**Kemps Creek Warehouse, Logistics and Industrial Facilities Hub (SSD 9522)  
Response to Submissions**

## Attachment 1

### The Department's Comments

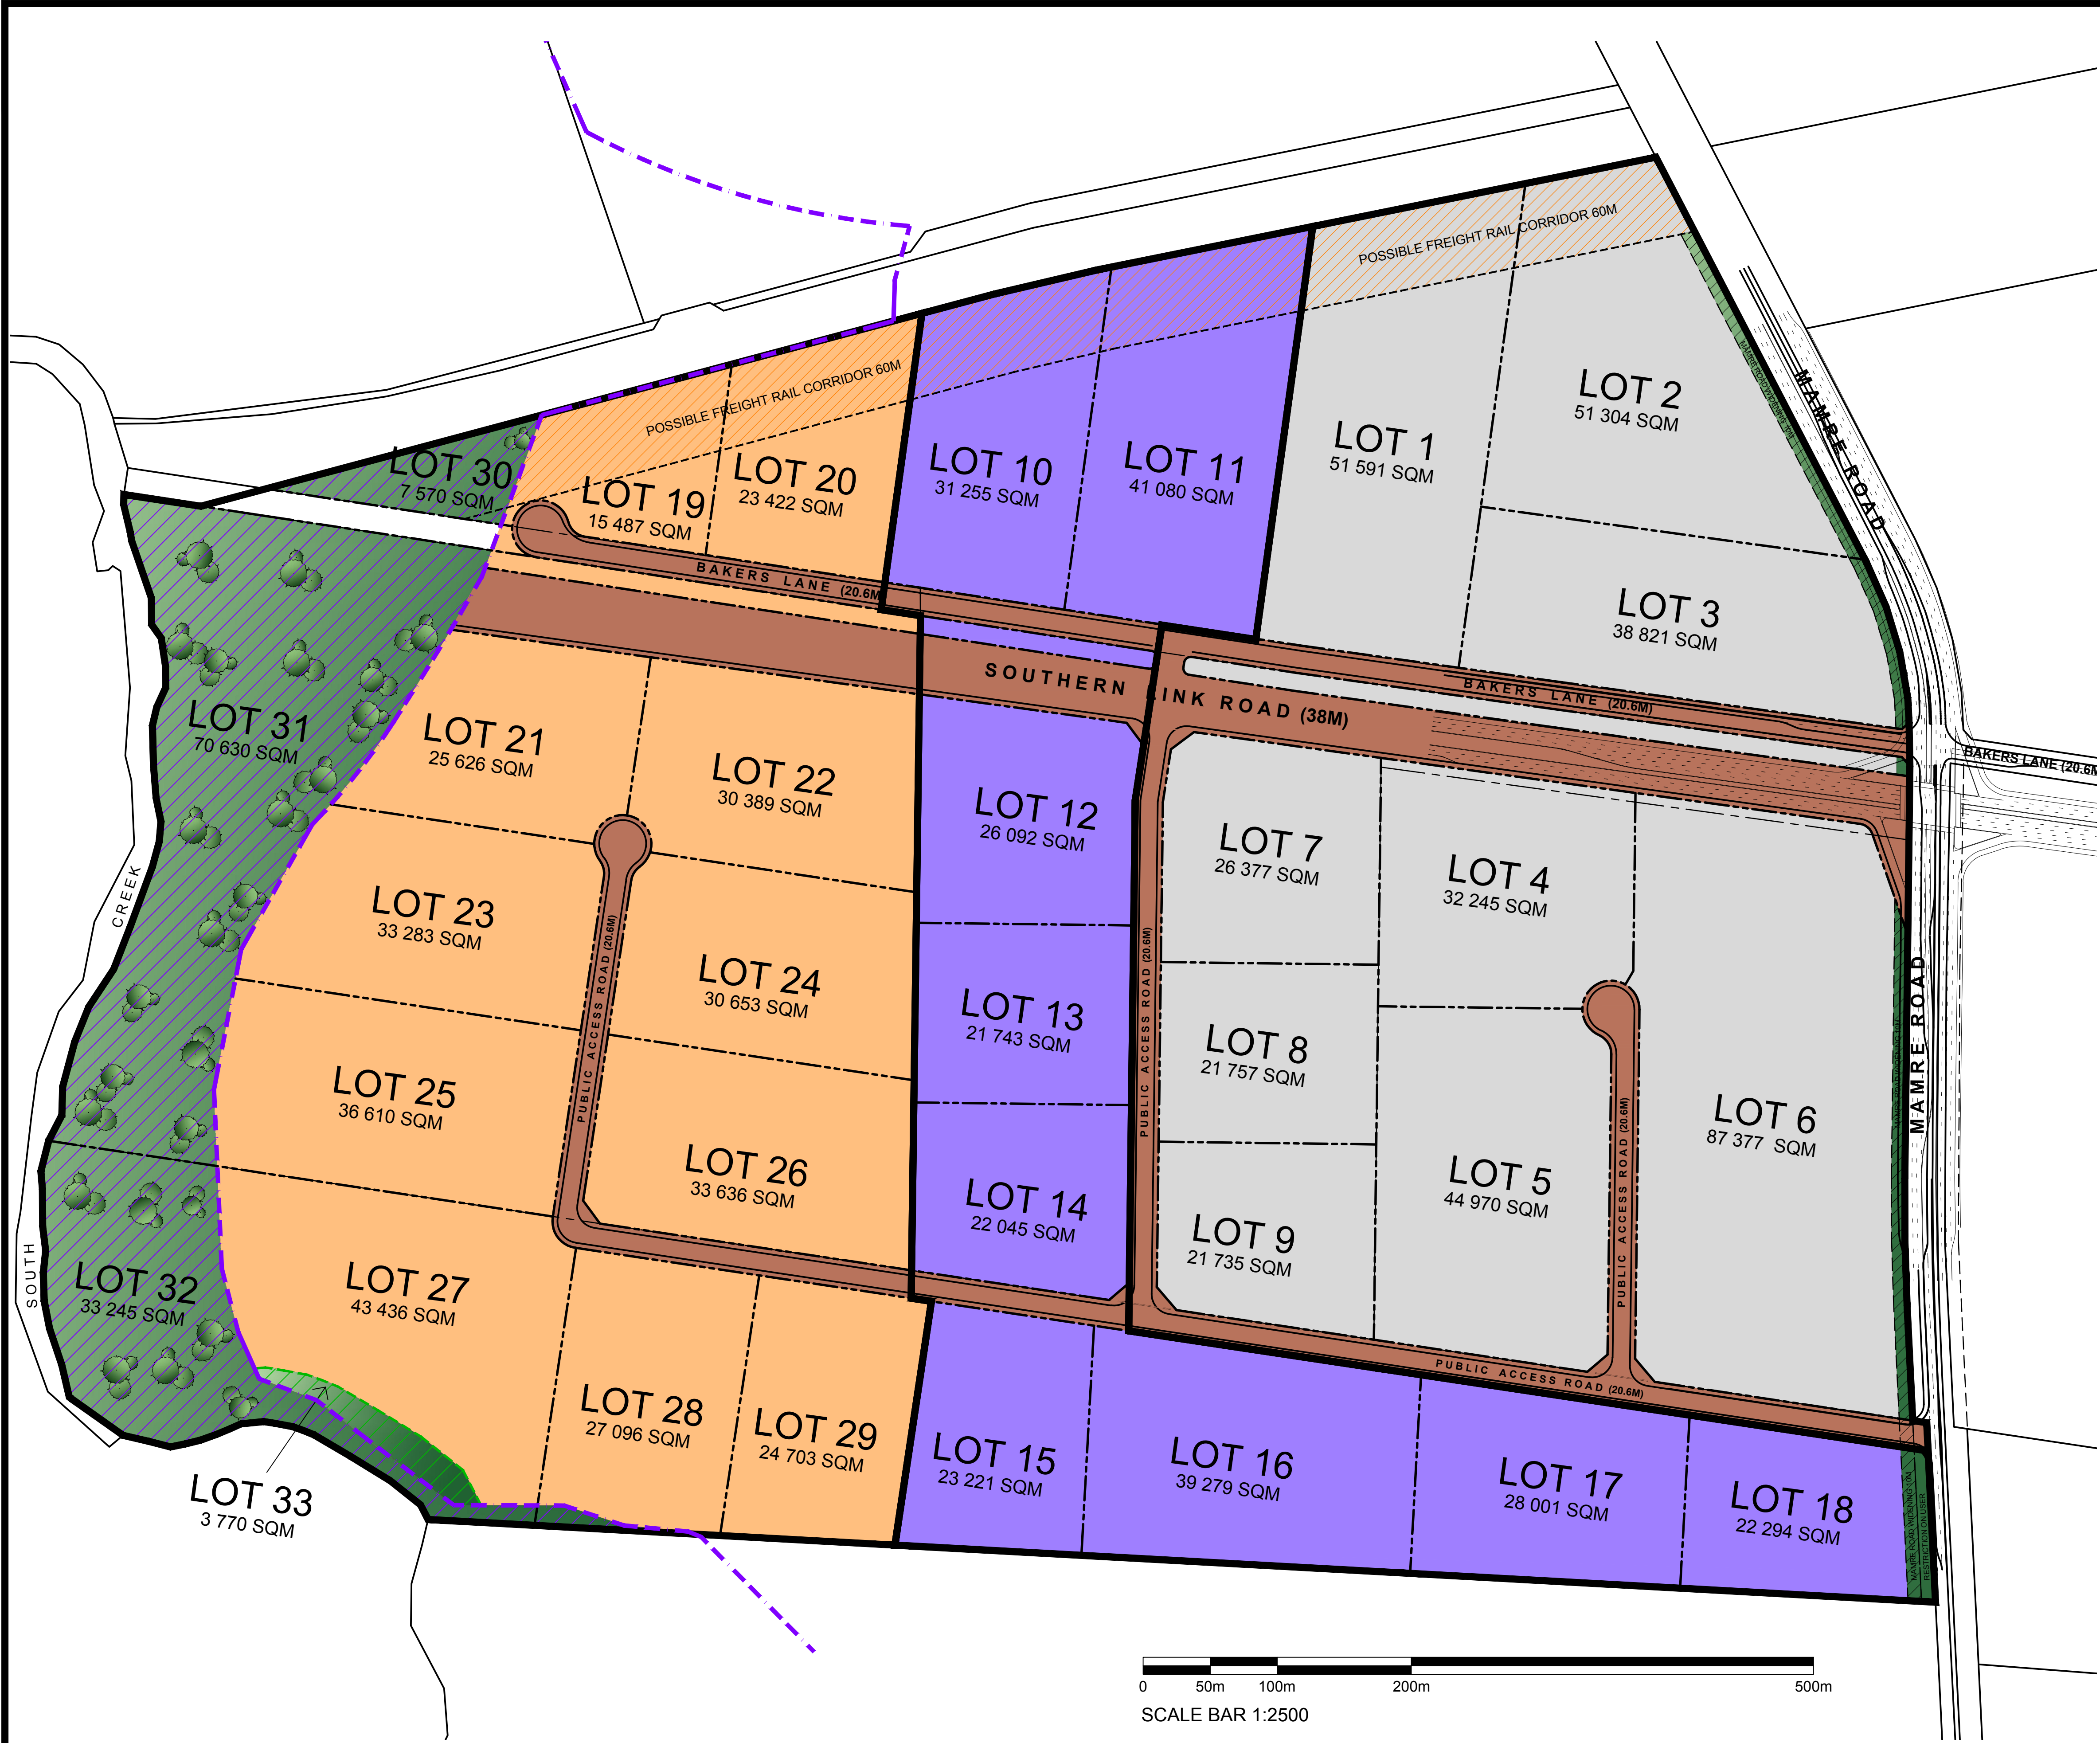
- The Stage 1 works as shown on Drawing Number DA-001 (Appendix 5) are inconsistent with the Stage 1 works shown on Drawing Number SP-KC1 DA-500 (Appendix 6).
